Subdivision Comments

From: Holly Erdman, Environmental Health Specialist II

RE: LP-22-00003 Haybrook Farms Ph 3

HAYBROOK FARMS PHASE 3
PART OF SECTION 30, T. 18 N., R. 19 E., W.M.
KITITAS COUNTY, WASHINGTON
- PRELIMINARY PLAT -

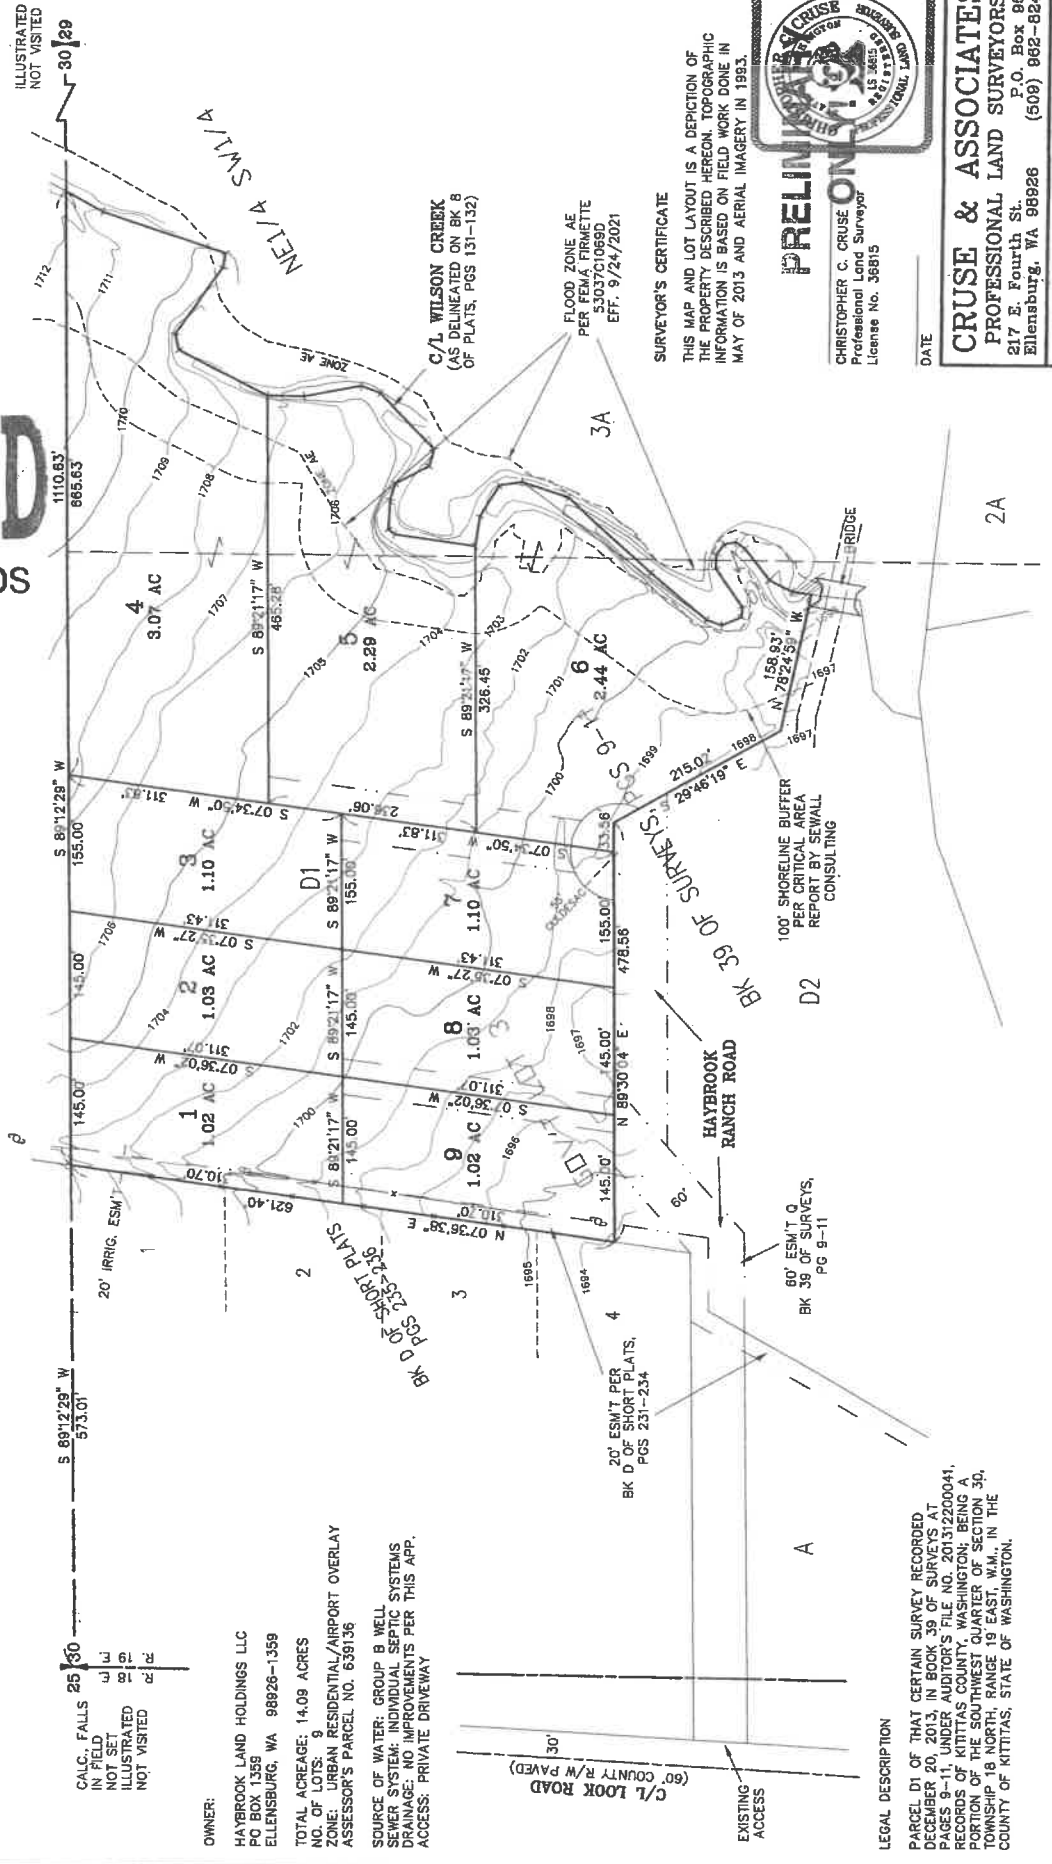
Any on-site septic systems that are to be utilized for wastewater management must adhere to the standards set by both the Washington Administrative Code, and Kittitas County Code. In accordance with KCC 13.04.090, a minimum of one soil log for each proposed lot where individual sewage disposal systems are contemplated must be completed. If community drain fields are to be utilized, soil logs must be done in the proposed locations of each.

The proposed short plat materials indicate the applicant will develop a Group B water system to serve the proposed lots. The applicant must prove legal and physical availability of water for all new uses of water on the proposed lots.

Soil logs are required on each lot proposed.

A Group B water system must be installed and approved with a state ID# issued. A well site inspection must be performed by the Kittitas County Public Health Department prior to drilling the well. Mitigation water for the 9 proposed lots must be provided.
